Arun District Council
Arun Civic Centre
Maltravers Road
Littlehampton
West Sussex BN17 5LF
Planning & Building Control General Enquiries
Tel: (01903) 737756 Fax: (01903) 730442
Dx: 57406 Littlehampton
Minicom: 01903 732765
e-mail: planning@arun.gov.uk
website: www.arun.gov.uk/planning

Application No: K/45/21/HH
Site Address: Sea Lodge Coastal Road Kingston BN16 1SJ
Description of works: Demolition and replacement of existing rear extension with new single storey extension and first floor terrace above with external staircase. Replacement of main roof and 4no. new dormers with windows. Replacement roof tiles to single-storey projections on North elevation. Proposed rear single storey minor extension to garage to form entrance lobby. Alterations to external facade of house and replacement windows and doors throughout. Associated landscaping to suit.

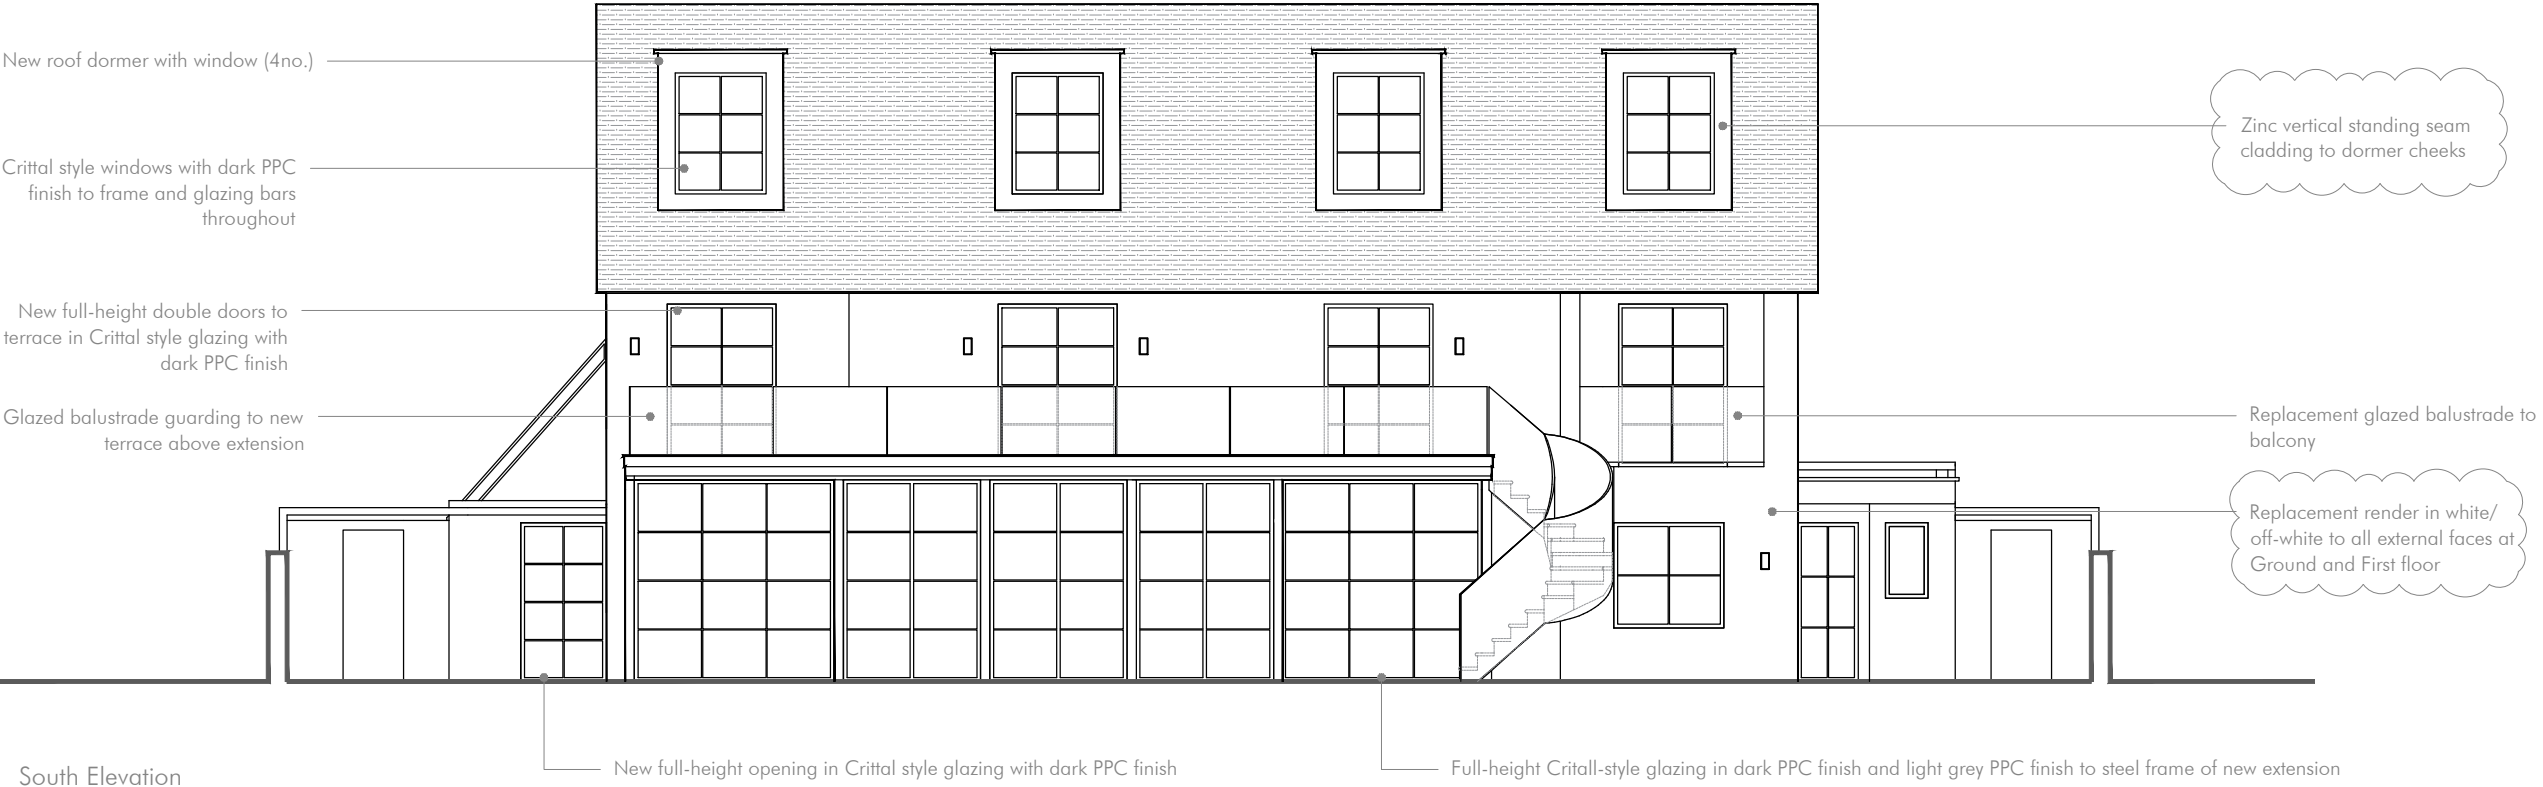
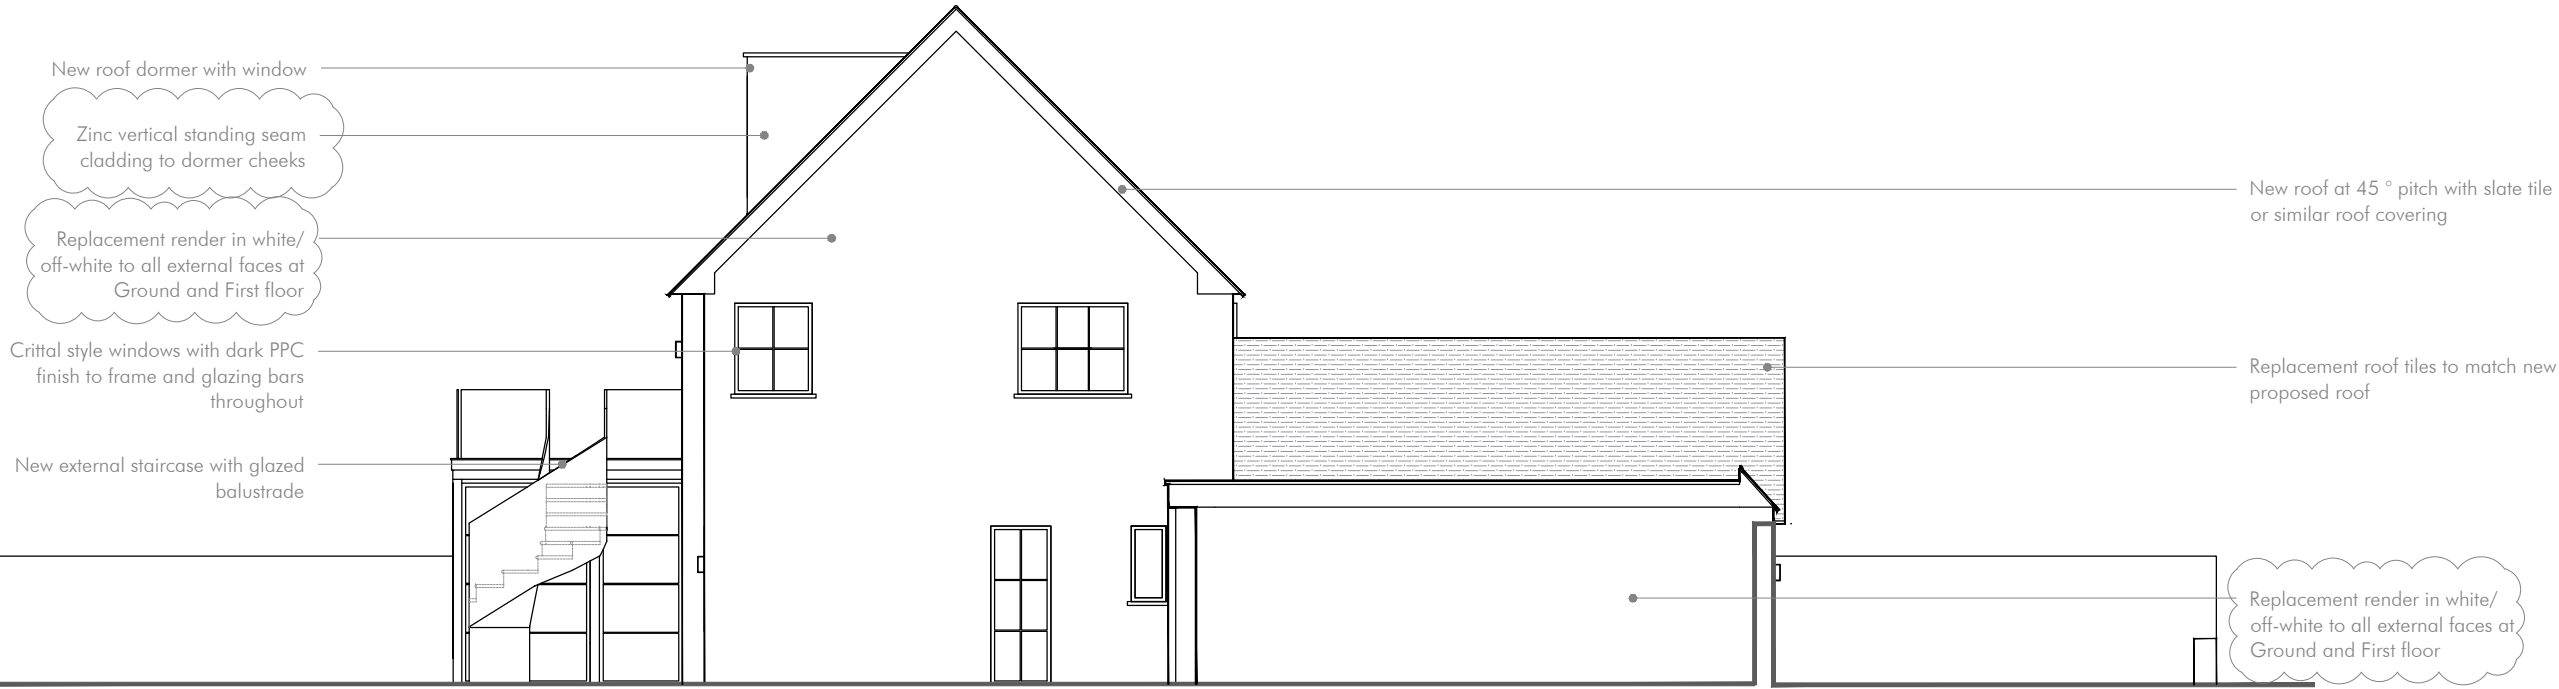
No objection providing the case officer considers whether conditions are required to prevent overlooking of neighbouring properties from the terrace and external staircase.
